From: [REDACTED]
Sent: Monday, 22 November 2021 9:57 AM
To: Thomas Bertwistle
Cc: [REDACTED]
Subject: HPE CM: Major Projects - New Request for Advice - Minto Logistics Hub - MOD 1 - Layout changes

I have reviewed the proposed modifications, overall I don't see any major issues with regard to the proposal but do have the following comments.

Drawing Title
SITE MASTERPLAN – STAGE 1, 2, 3 & 4

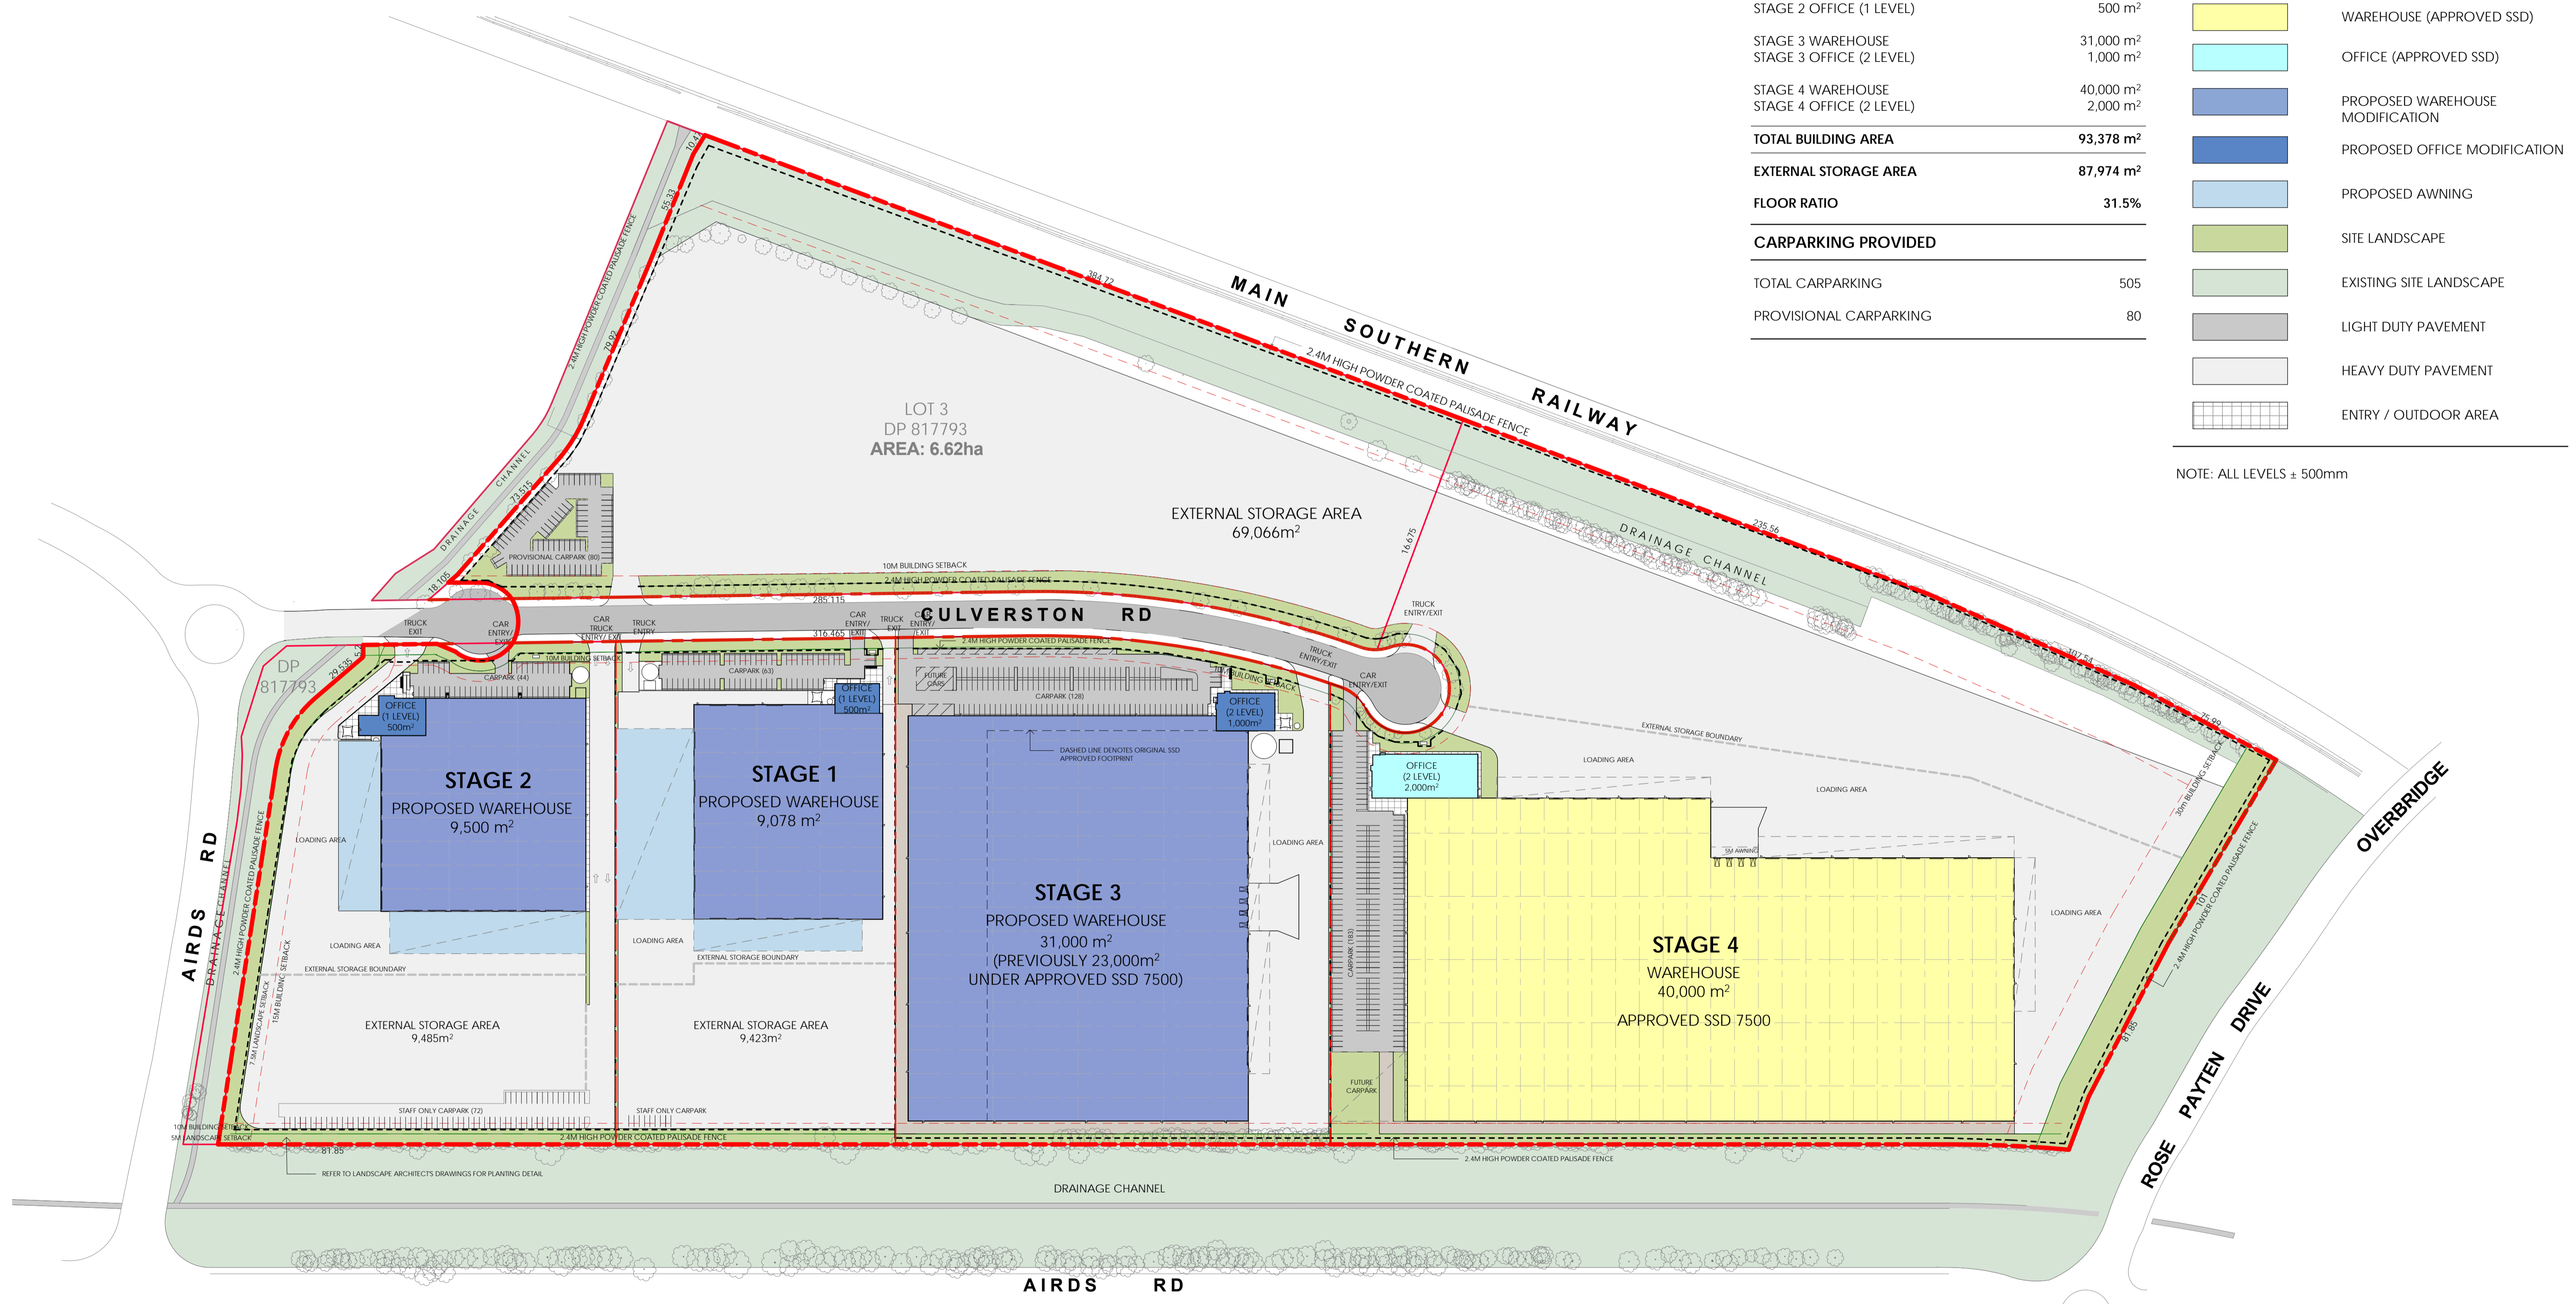
- The reduction and warehouse size and increase in outdoor storage is acceptable.
- The relocation of the loading bays and driveway access to 1B (Stage 2) may need further consideration given the proximity of the driveway to the intersection/ roundabout.
- Council requests that consideration is given to the screening and visibility of the new external storage areas from Airds Road and details are obtained on the maximum height of external storage, or alternatively a limit is placed on the height of external storage.
